Application No: LU/55/22/L
Site Address: The Flintstone Centre East Street Littlehampton BN17 6AW
Description of works: Listed building consent for the installation of 3000mm high welded mesh fencing and associated single leaf gate along a section of the northern boundary line and along the rear elevation, Ornamental fencing and associated gates to be installed, located adjacent to the existing southern side entrance to the building, as well as the installation of 3000mm high welded mesh fence encapsulating the existing boiler room to the rear of the building, demolition of existing side secondary entrance including existing ramped access and associated fittings. Repairs to the section of wall affected by the removal of the entrance.

Thank you for your internet representation made on 9th March 2022 which has been recorded as an objection with the comments as follows:

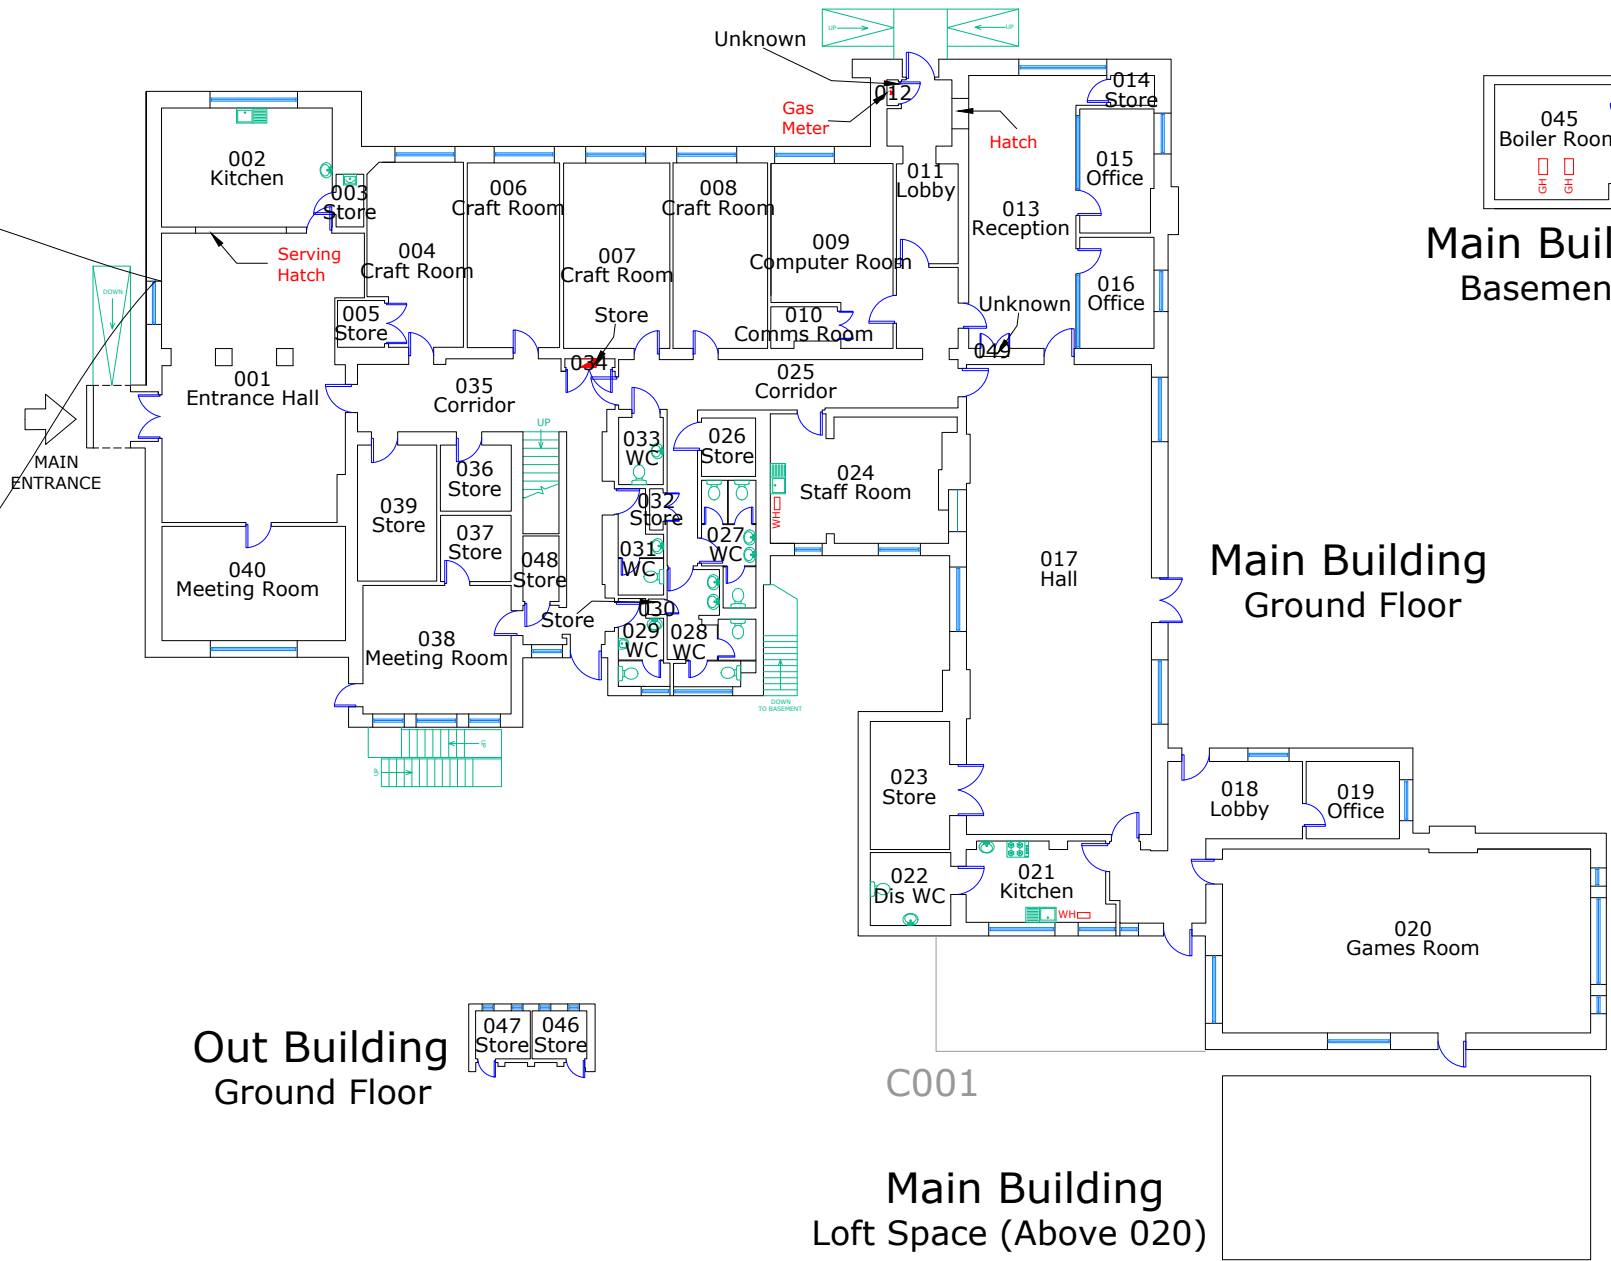
The Location Plan and Proposed Fencing Layout plans do not show our four year old development to the rear (The Old Dairy Farm) giving a very misleading view of the impact of the mesh weld fence to the rear.

Title:
THE FLINTSTONE CENTRE
FENCING LAYOUT AS PROPOSED

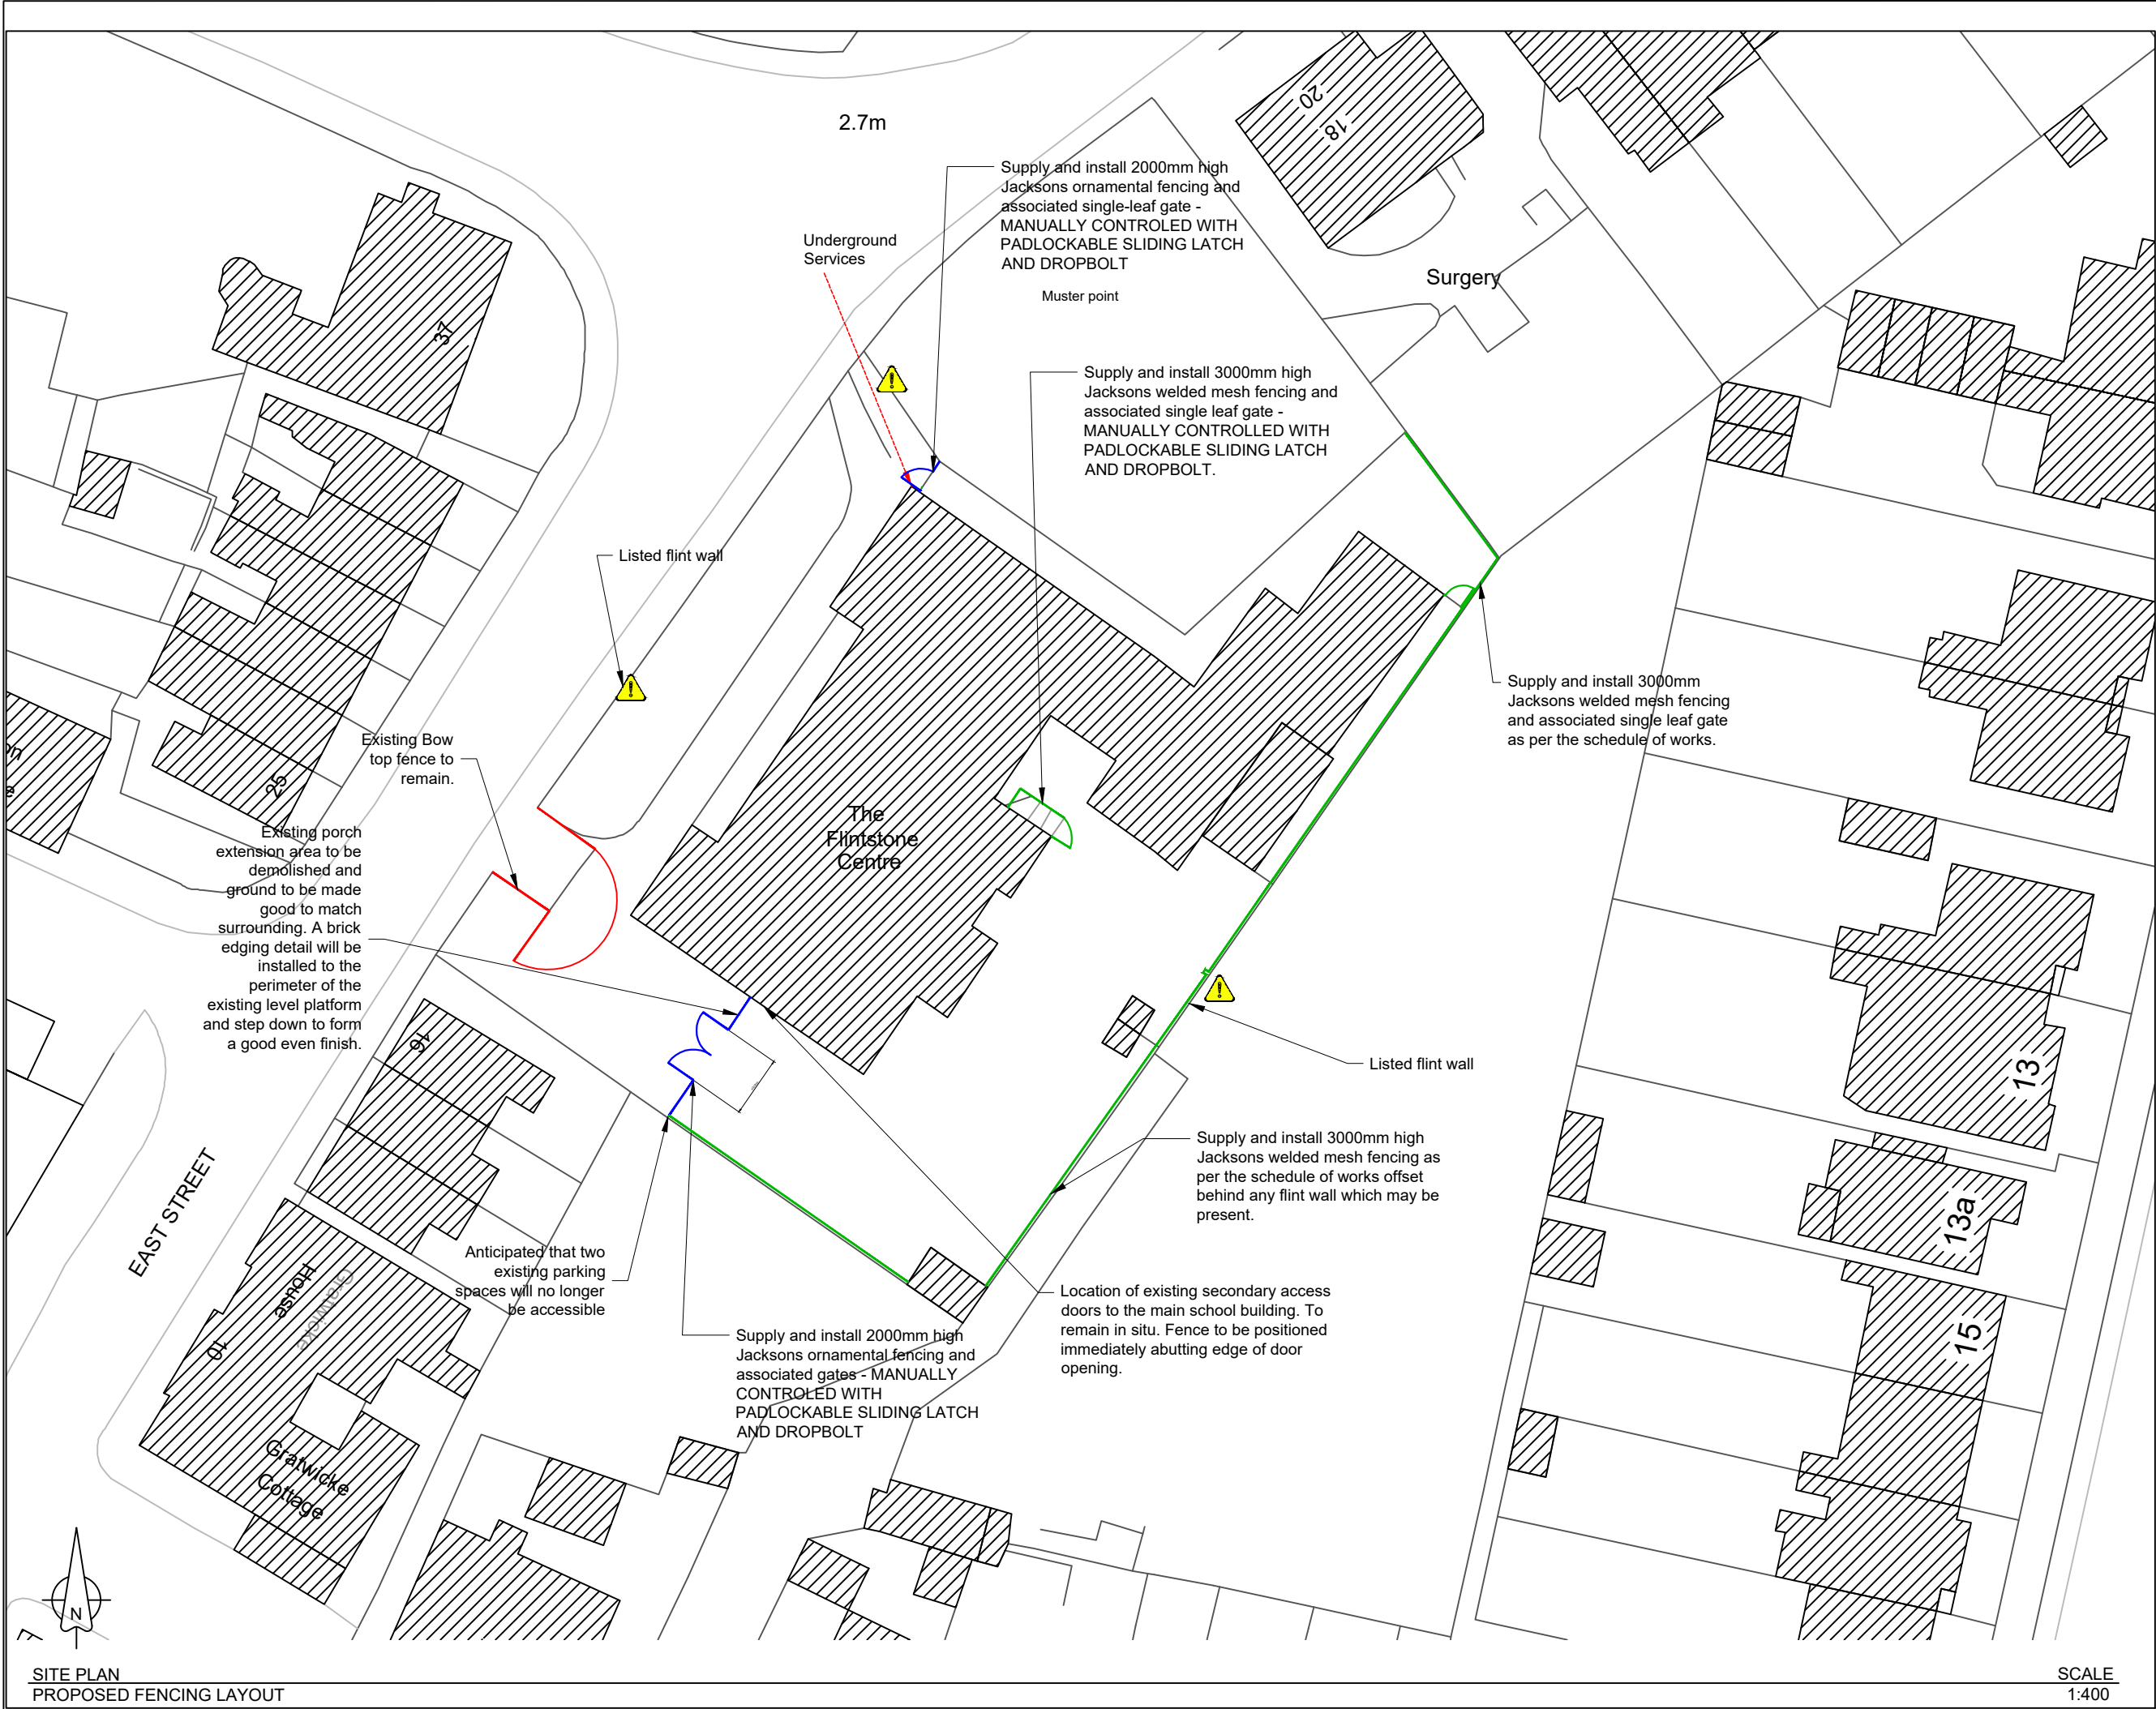
The application appears to take little account of The Old Dairy Farm (it is not shown on the plans), ignoring the fact that we will have full view of the weld mesh fencing, all and every day.

The Heritage Impact Statement says that the rear flint wall is not listed, yet the Proposed Fencing Layout plan says it is listed. Which is correct?

Does the proposed fencing design allow for maintenance of the flint wall?

This weld mesh fencing would be visually incongruous to the residents of The Old Dairy Farm. It would be erected within 10m of the front facade of numbers 1-5 The Old Dairy Farm, protruding above the existing flint wall, and also along the garden wall of number 8. The Euroguard weld mesh fencing looks more appropriate for use surrounding a prison or similar. Previous discussions with the Council stressed that the planning submission would include heritage/conservation style fencing to the rear, and not an ugly and inappropriate weld mesh fence.

Drawn S.leeper		TITLE SALES DRAWING 2m HIGH EUROGUARD REGULAR FENCE	
Date 15/06/2006			
Checked Chris J		CUSTOMER ACK No.	Drawing No. J6/01058 Sheet 3
Size A3	Scale 1:20 U.O.S

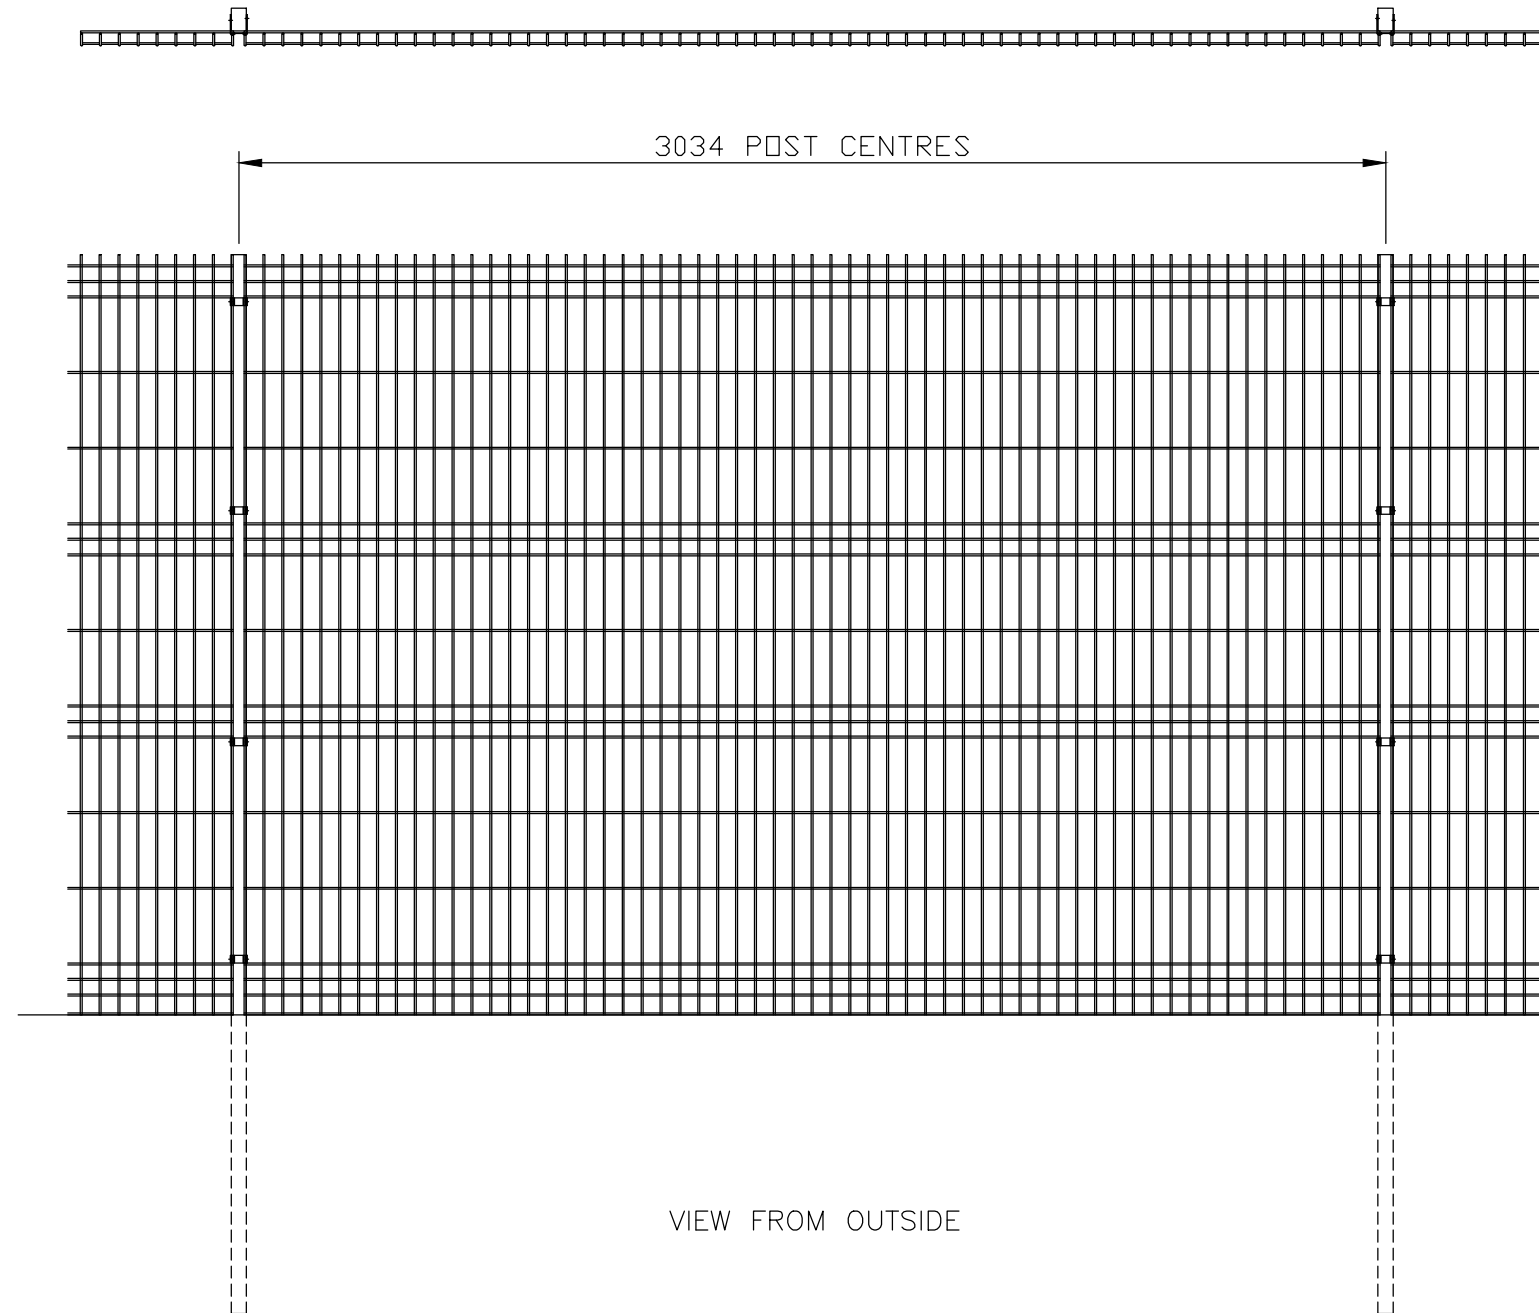
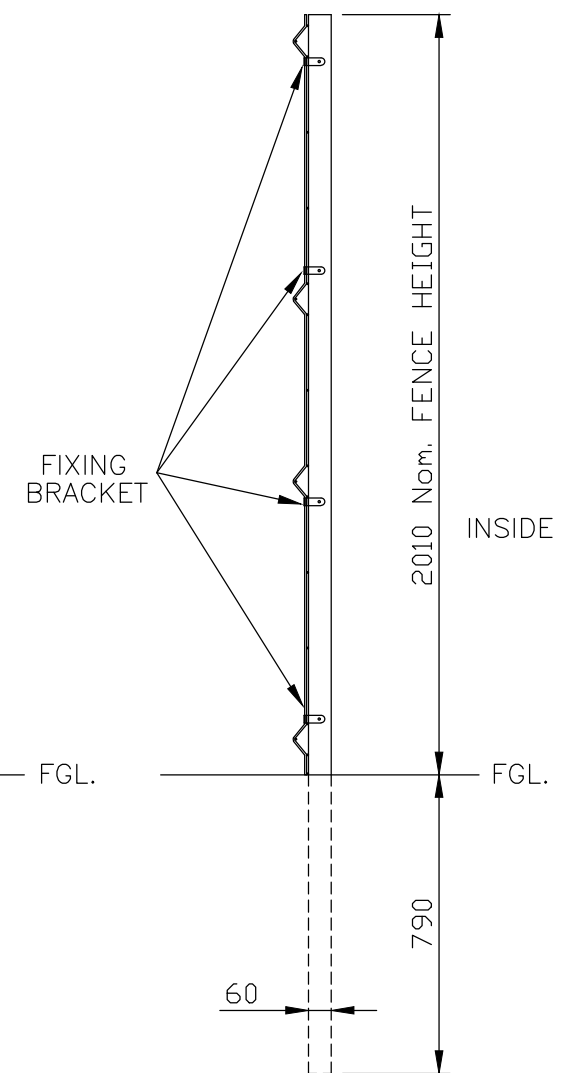
The proposed fence is welcomed as a measure to stop pupils from the school climbing over the wall to and from our development, The Old Dairy Farm, which sits behind the Flintstone Centre. However, the proposed Euroguard weld mesh fence is ugly and inappropriate, especially considering that this is a conservation area and that tight planning restrictions requiring an ornamental/heritage style gate and fencing were applied to the Old Dairy Farm development just to the rear.

The proposed Euroguard weld mesh fence is not in any way in keeping with the conservation area and would be erected within 5m of the heritage design and materials used for the gate and fence to the Old Dairy Farm.
